From: Zac Denton
Sent: 25 July 2019 09:34
To: Planning Scanning
Subject: FW: Mistletoe Farm, Horsemere Green Lane. CM/13/19/RES; Revised Drainage Proposals

Drawing Title				
Engineering Details Drainage Strategy (with Ditch)				
Drawn	Checked	Scales	Paper Size	Date
KN		1:250	A1	07.19
Job No.	Drawing No.	Revision		
ES1820	602-04	C

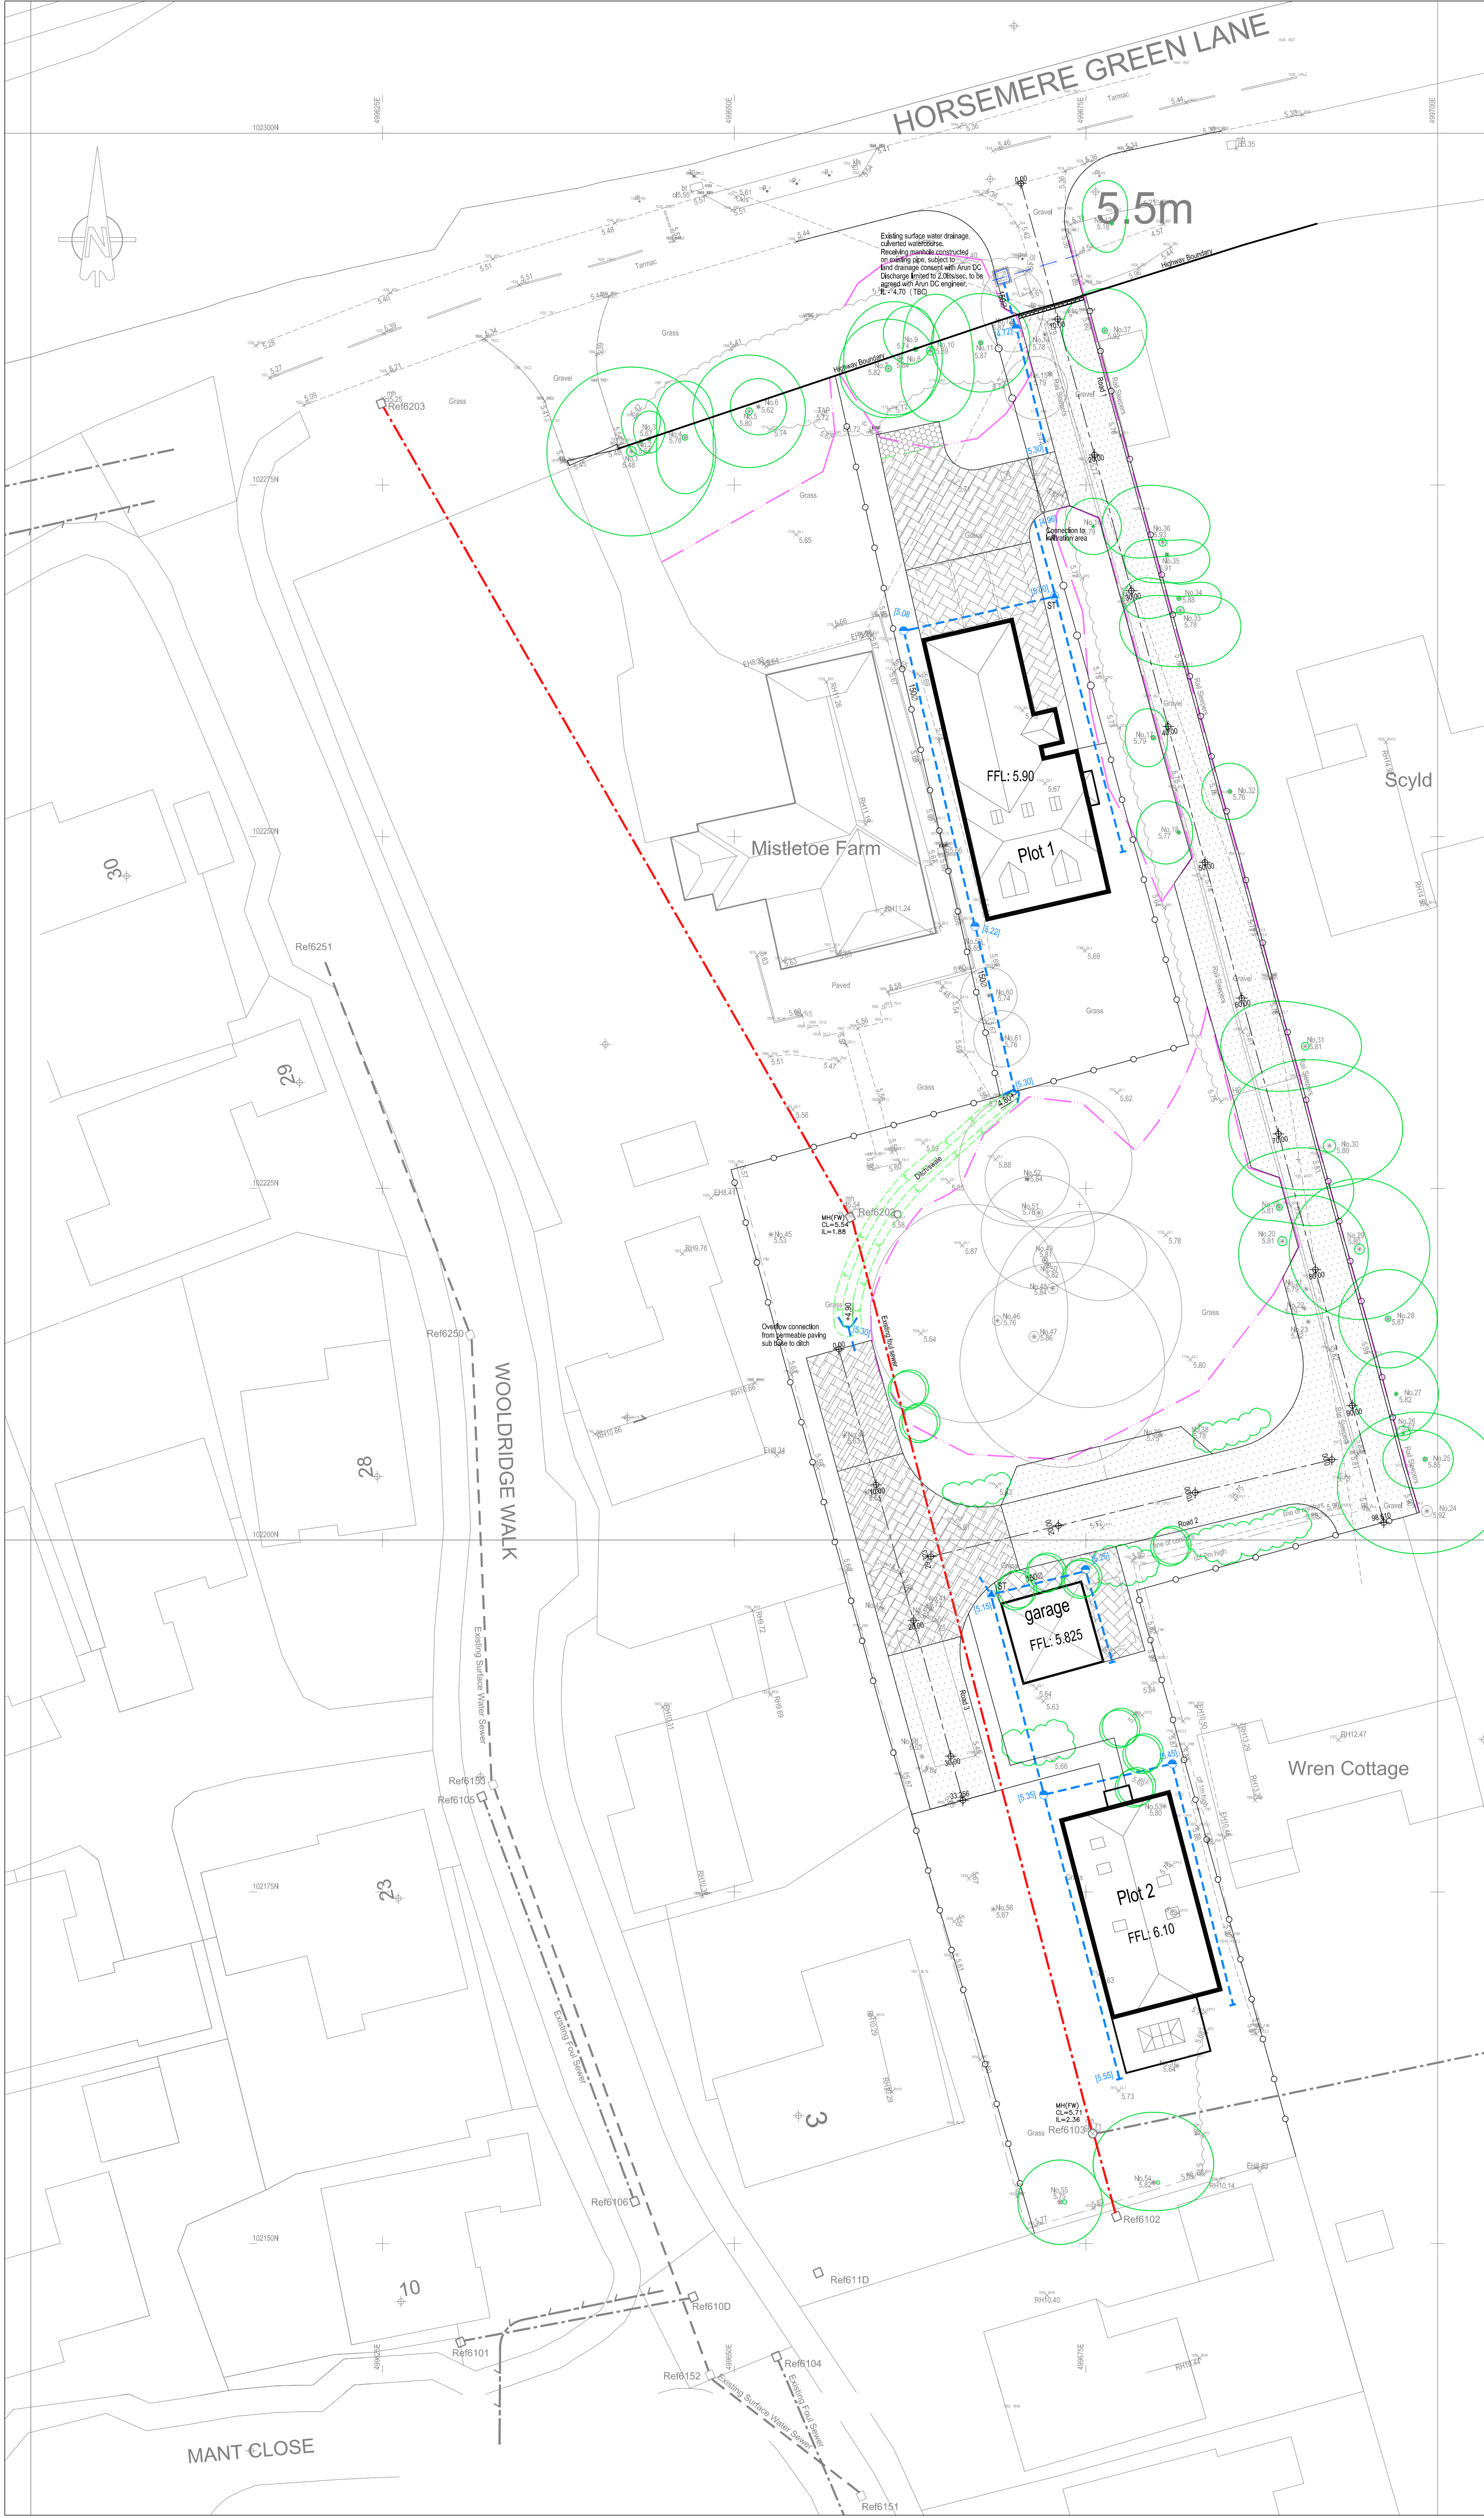
Thank you for sending over the revised plan. I believe there is some conflict between what you are proposing and the tree protection plan (attached).

The permeable paving for plot 2 looks like it could only be located in the T furthest round on the road rather than at the junction of roads 1 and 2. The swale also appears to be within a no dig area.

Thank you for your comments. I was under a misapprehension regarding the RPZ so having cleared that I have put together a revised proposal which addresses your comments on the RPZ. Hopefully you find this revised proposal accords with your thoughts and you are able to advise your planning colleague that we have reached a drainage solution. As always, if you have any further concerns please contact me. Many thanks.
